From: skelly@richardbuxton.co.uk
To: hornseaprojectthree@pins.gsi.gov.uk
Cc: "Mulbarton Parish"; [REDACTED]
Subject: EN010080 - Hornsea Project Three, Deadline 8 Representations on behalf of Mulbarton Parish Council
Date: 20 March 2019 11:12:46
Attachments: [Ltr_Mulbarton Parish Council_EN010080.pdf](#)

Planning Inspectorate Reference: **EN010080**

Application by Orstead Hornsea Project three (UK) Ltd for an order granting Development Consent for the Proposed Hornsea Project Three Offshore Wind Farm (the Application)
Application Reference: EN010080

Deadline 8: Representations on behalf of Mulbarton Parish Council

Figure 3.10: Substation B.

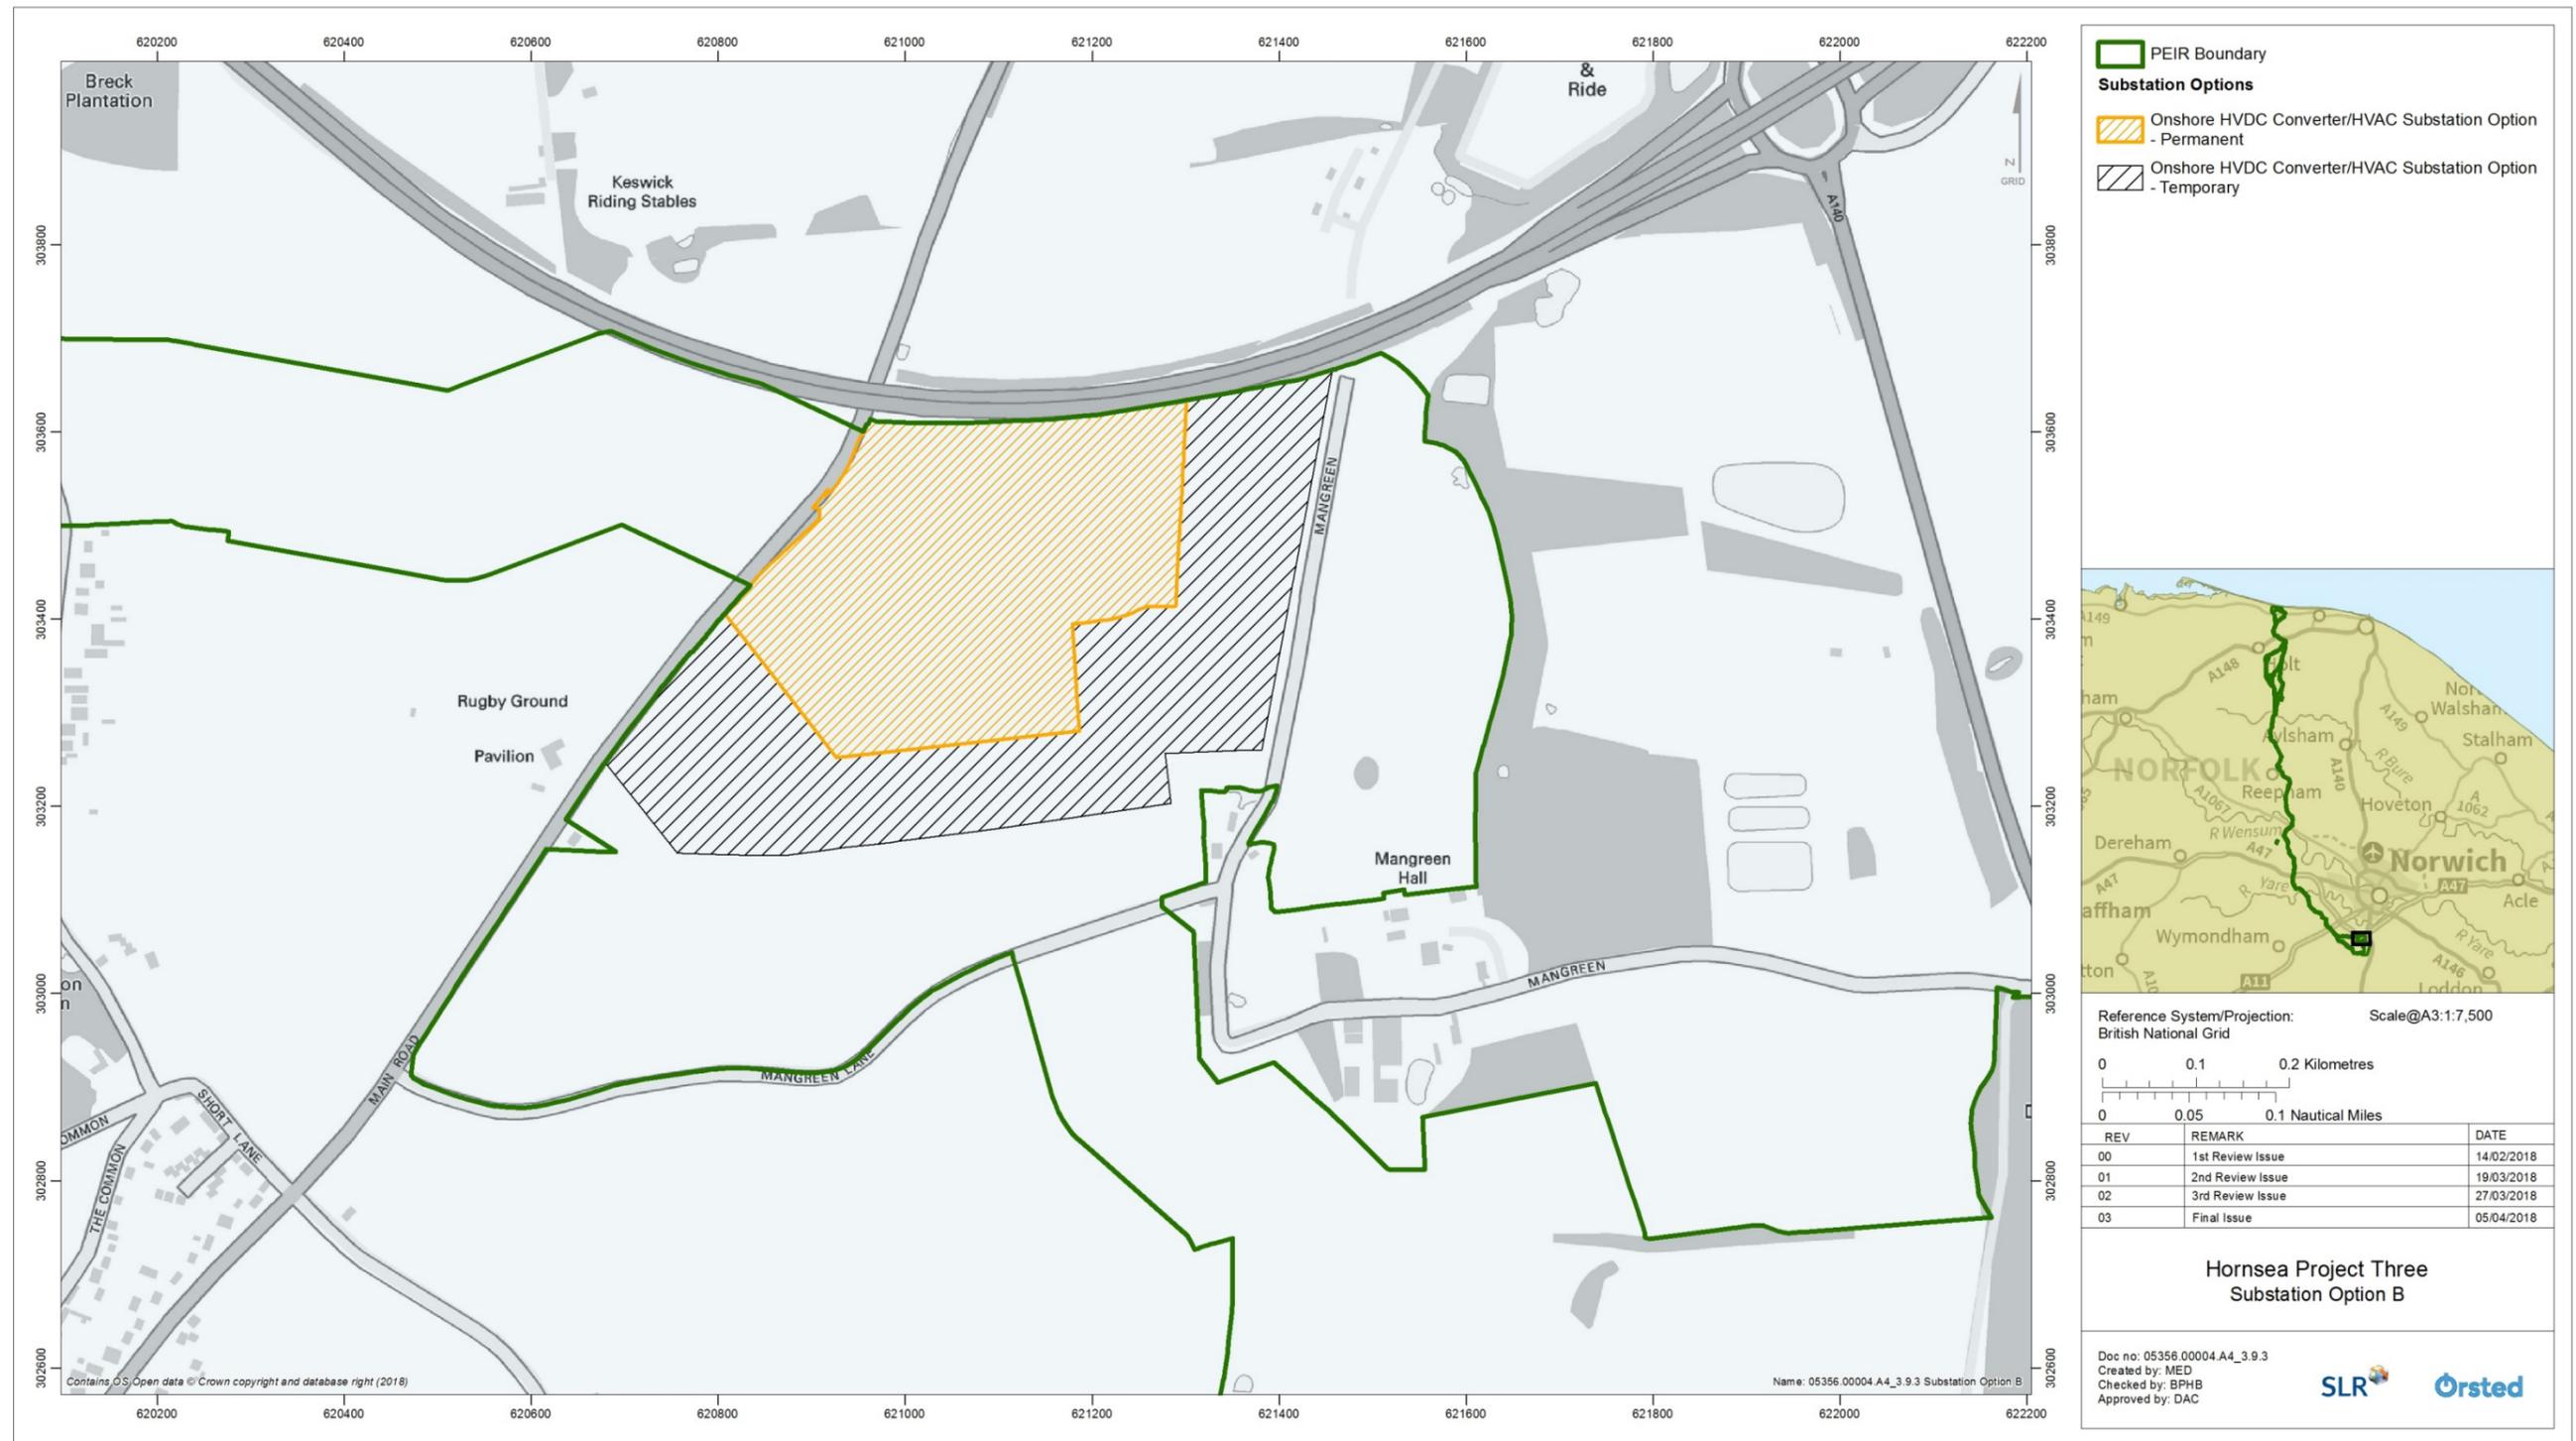
18. Option B is a roughly square site, lying in the 'elbow' between the B1113 and the A47, directly adjacent to both roads. Again, the site currently comprises an open field. Unlike the Option A site, the Option B site is highly visible, being screened only by relatively low hedgerows. It sits within the Norwich Southern Bypass Landscape Protection Zone, partly within a viewing cone towards Norwich, and the B1113 at this point is designated an 'undeveloped approach' in local plan policy. It appears that access will be taken directly from the B1113.

20. In addition, the Option B site lies within the setting of the following listed buildings and parkland:

- Mangreen Hall (Gd II*), Mangreen Lodge (Gd II) a Gd II listed barn at Hall Farm, and the Grade II wattle cottage (all to the South West)
- Gowthorpe Manor and related 17th Century Barn (Gd II*) (to the South)
- The registered park to Intwood Hall (to the North West); and
- Keswick Hall (Grade II) and parkland to the north.

24. In respect of Keswick Hall, the examiner is asked to note that the entrance to the Option B Site and the related cable corridor are in the direct line of sight to Keswick Hall. Obviously, no tree screening can be planted across either site entrance or along the cable corridor. Unsurprisingly therefore, the Statement of Common Ground dated March 2019 records South Norfolk's concerns about the impact on the parkland at Keswick Hall and the setting of Keswick Hall. In South Norfolk's view, "if the proposed onshore HVDC converter station is constructed, any landscape mitigation planting will not adequately mitigate for the loss to the landscape character and visual impacts or the impacts on the setting of Keswick Hall and its parkland". The Statement of Common Ground goes on to observe that "If the height were to be reduced to 15m through the use of HVAC technology, then the mitigation would be more successful".
